LSC Responses to TIS
Redline comments -
Preliminary Plan 1

Monument Ridge East Traffic Impact Study

EPC PCD File Nos. SP 241, P245, P246
(LSC #S234450)
August 7, 2024

Figure 14
Recommended Signs
Along Monument Hill Rd
Monument Ridge East (LSC# S234450)

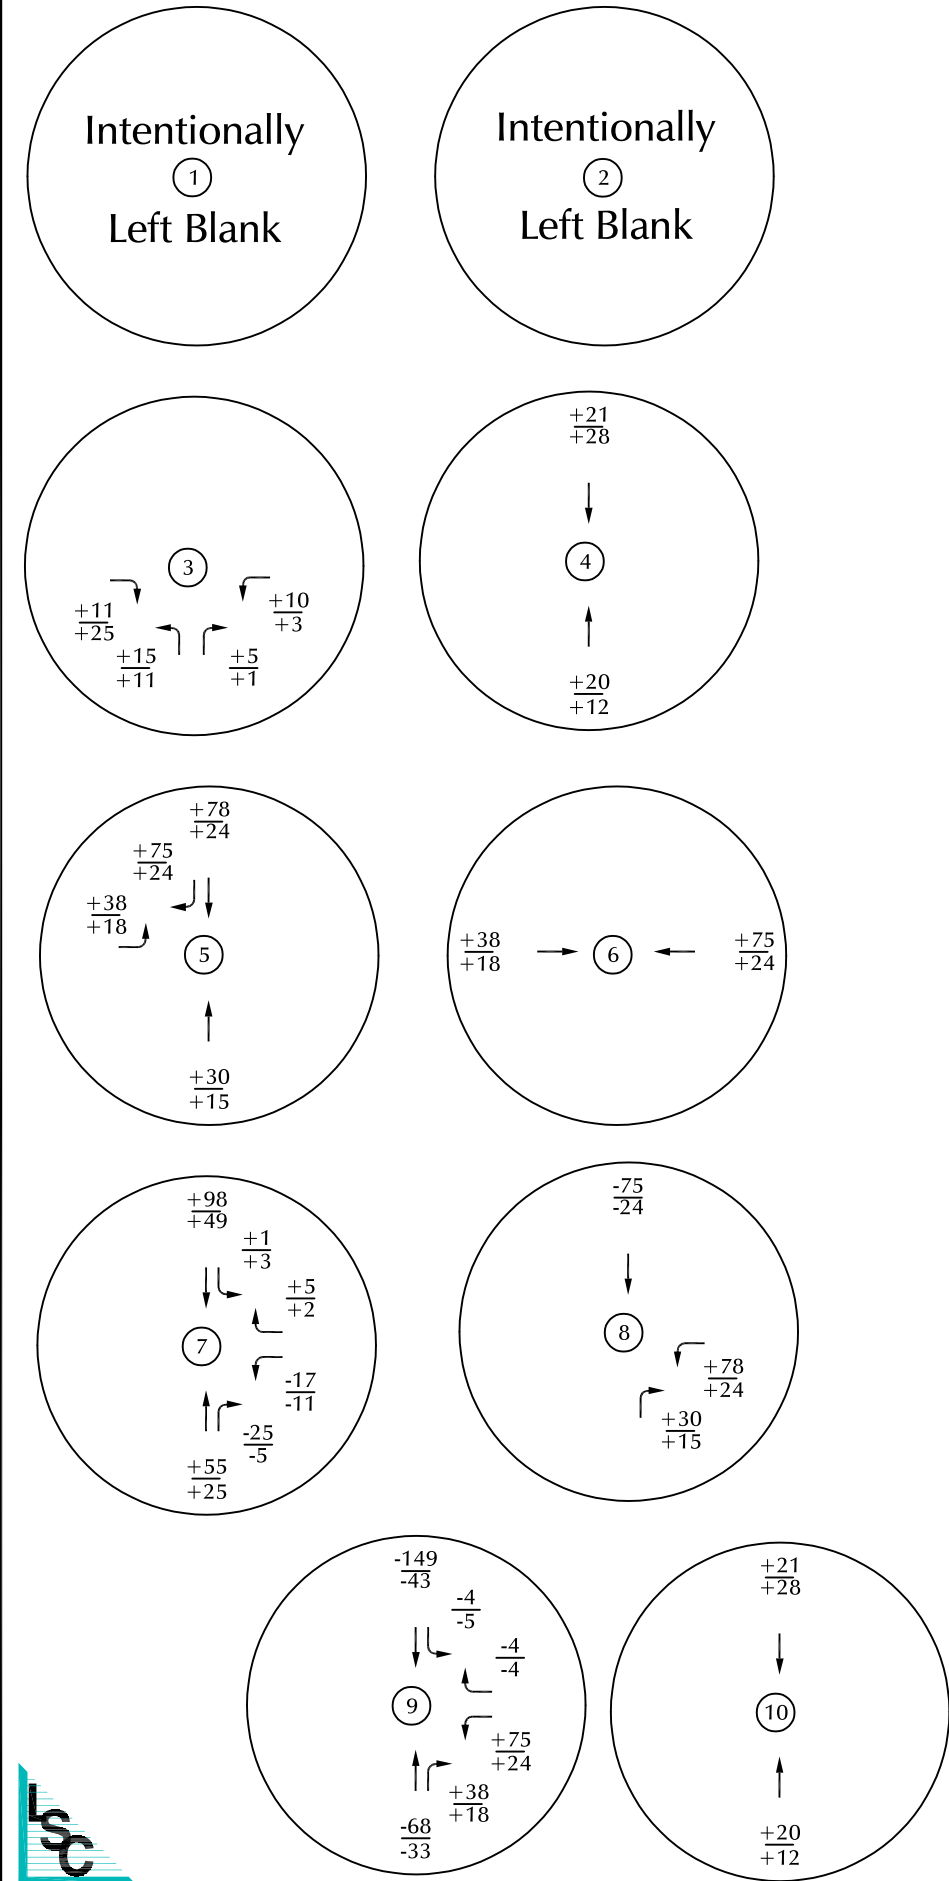
[please show location on a plan](#)

Author: jchodsdon Subject: Sticky Note Date: 10/4/2024 18:50:46
LSC Response: The updated report contains a new Figure 14 to address this comment.

Exhibit 1a

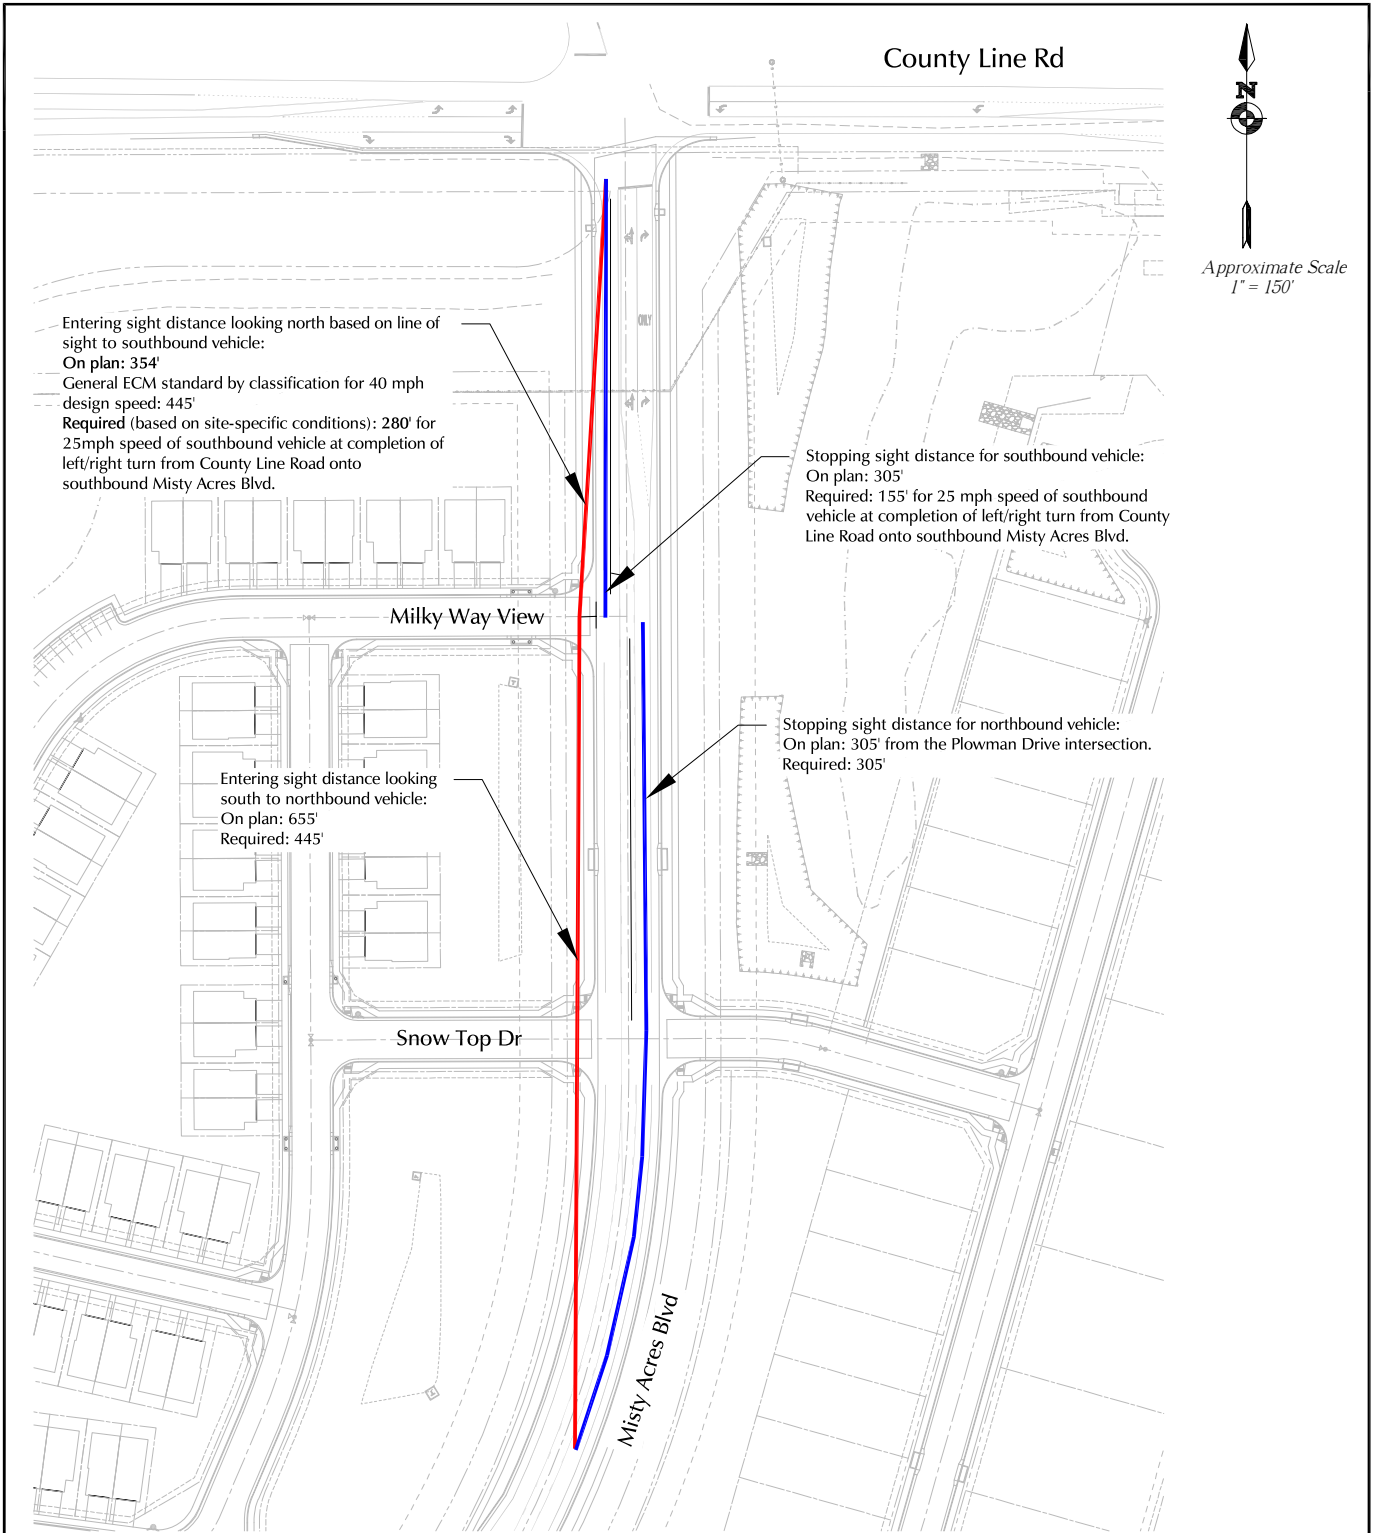
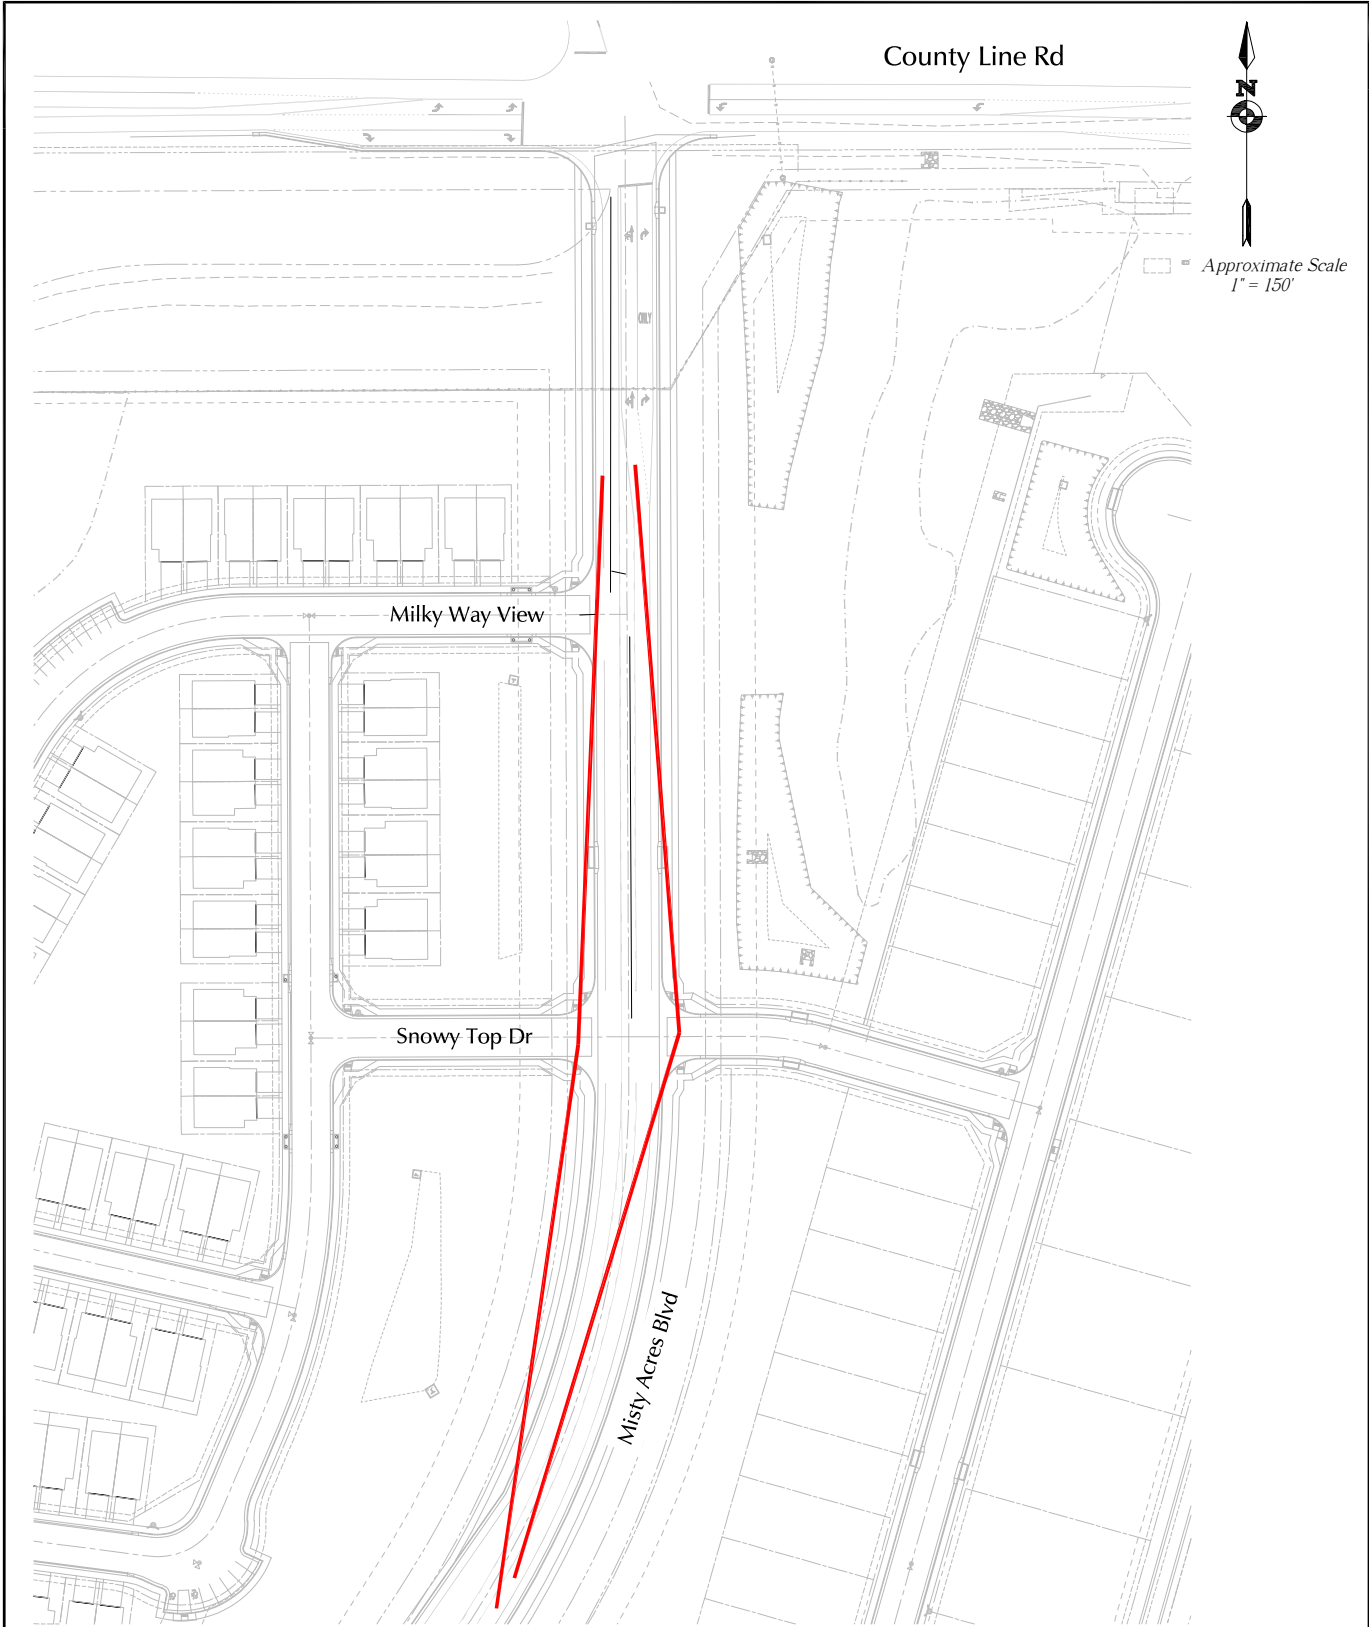
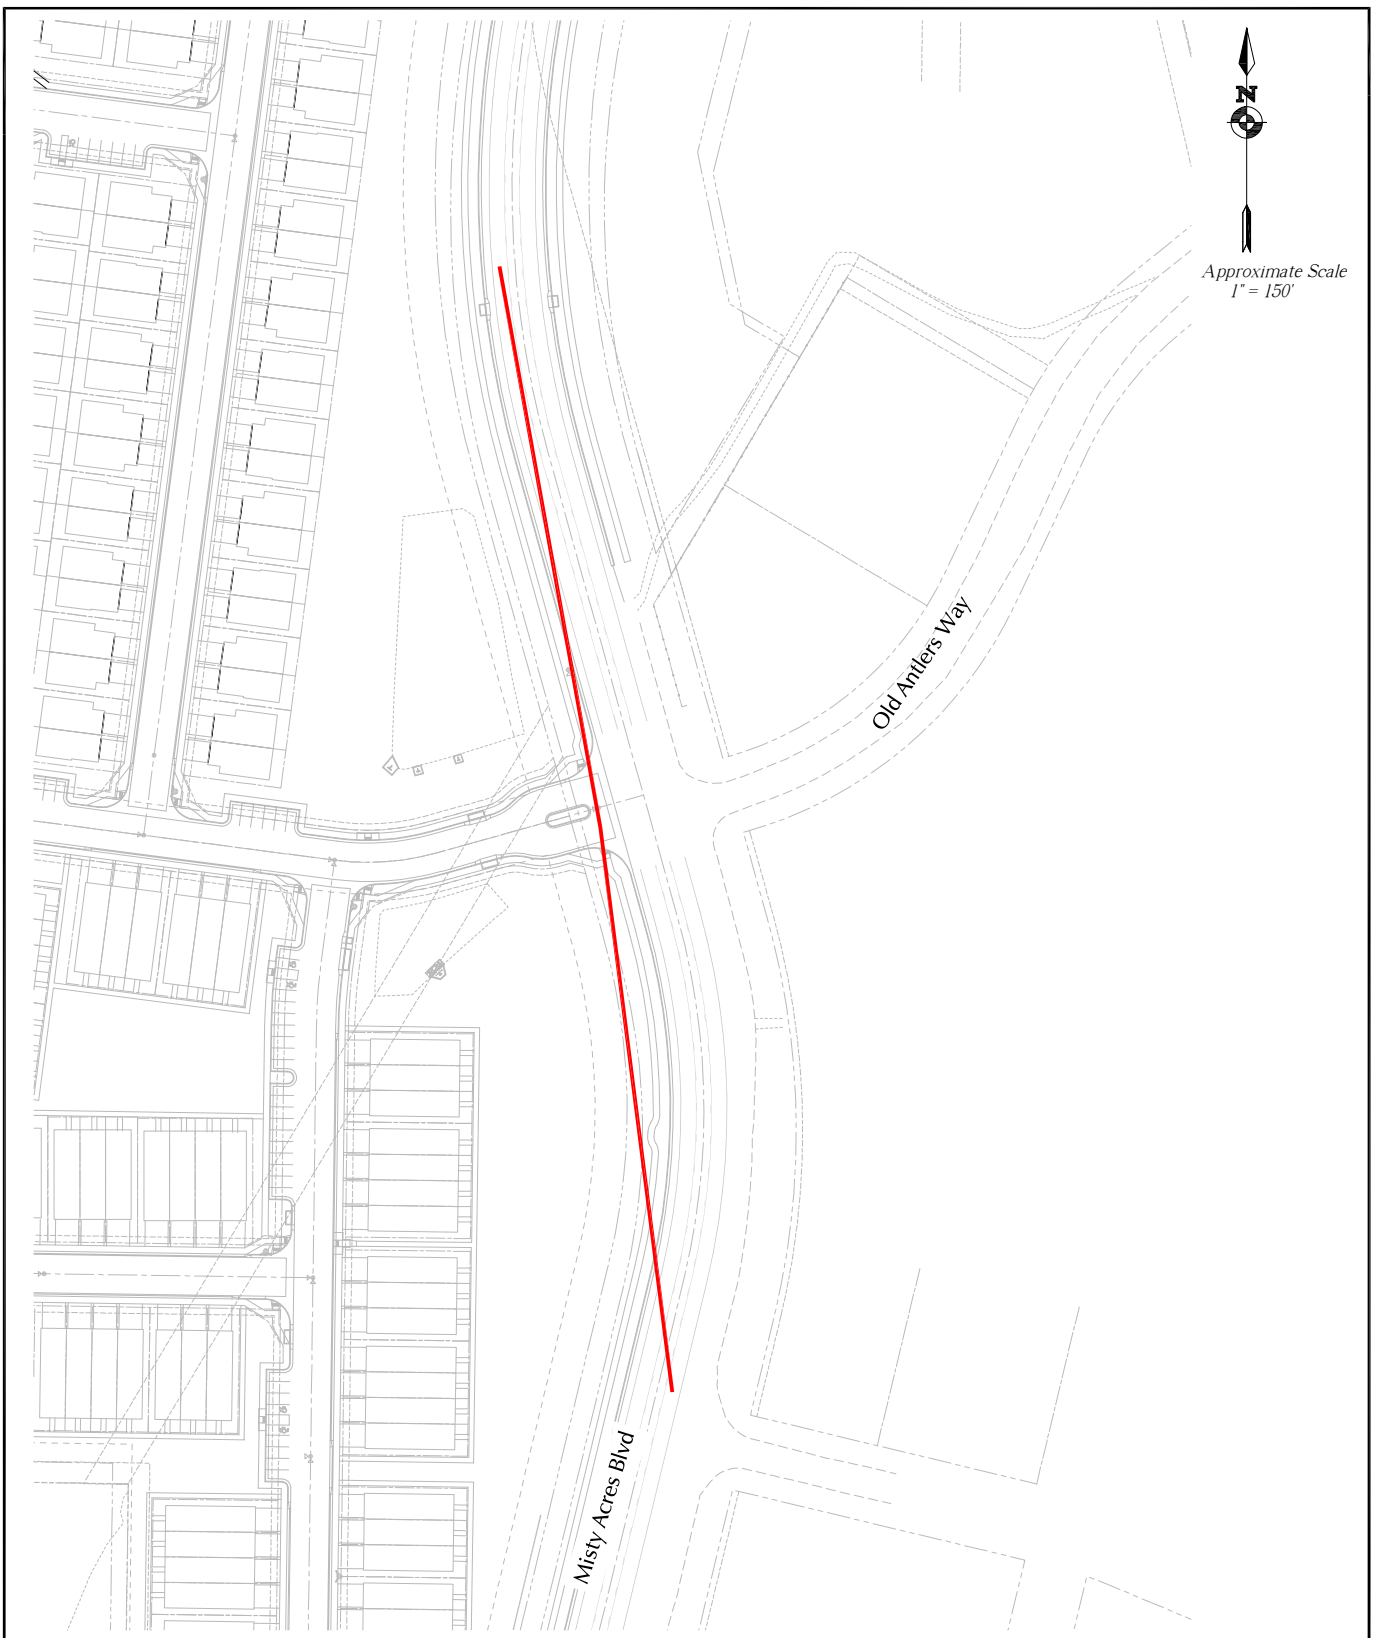
[Include sight distance exhibits for remaining intersections](#)

Additional sight distance figures have been added for the missing intersections. Only horizontal sight distance requirements are shown on the exhibits. Vertical to be verified with plan-and-profile design at a later design stage.
